Response to Planning Application

From: Arun District Council Greenspace

Application ref: BR/234/20/PL

Location: Aronel Cottage Nursing Home 5-11 Highfield Road Bognor Regis PO22 8BQ

LANDSCAPE LAYOUT PLAN

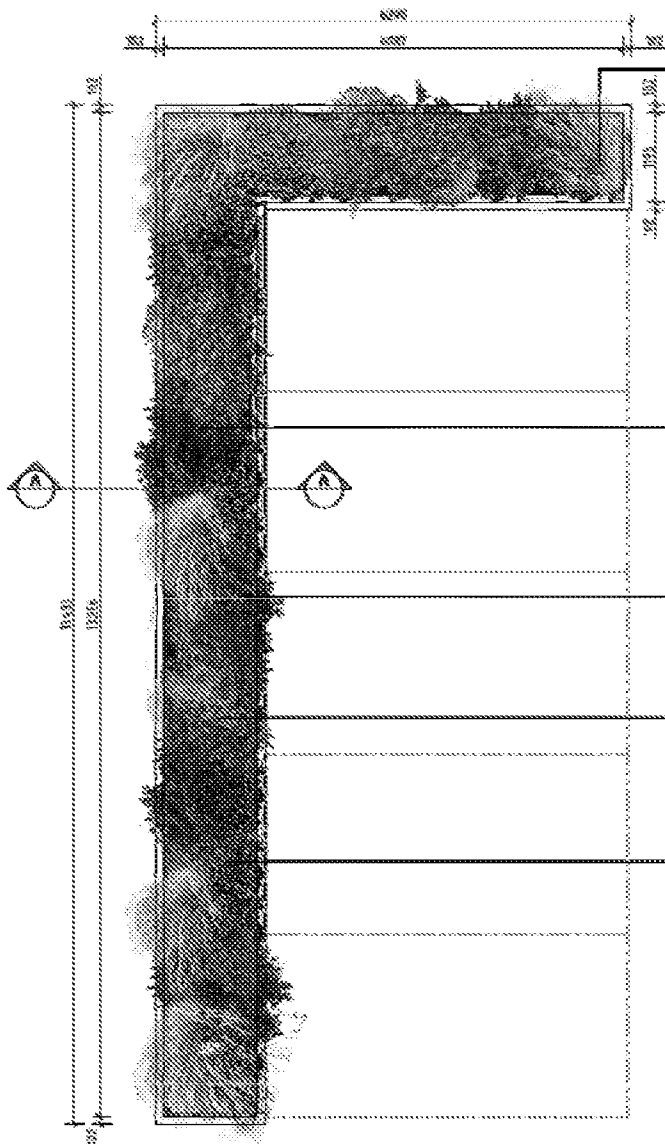
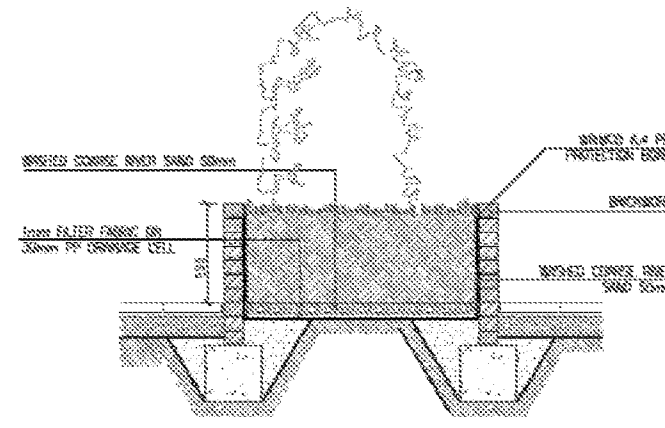
The potential impact of the proposals would blend into the surrounding environment, there would be little space for onsite green infrastructure in the form of any screening however some greening to the car park area would be required, which has been shown in the form of a raised planter.

Landscape mitigation in the form of raised planter as above, plan to show plant species and quantities.
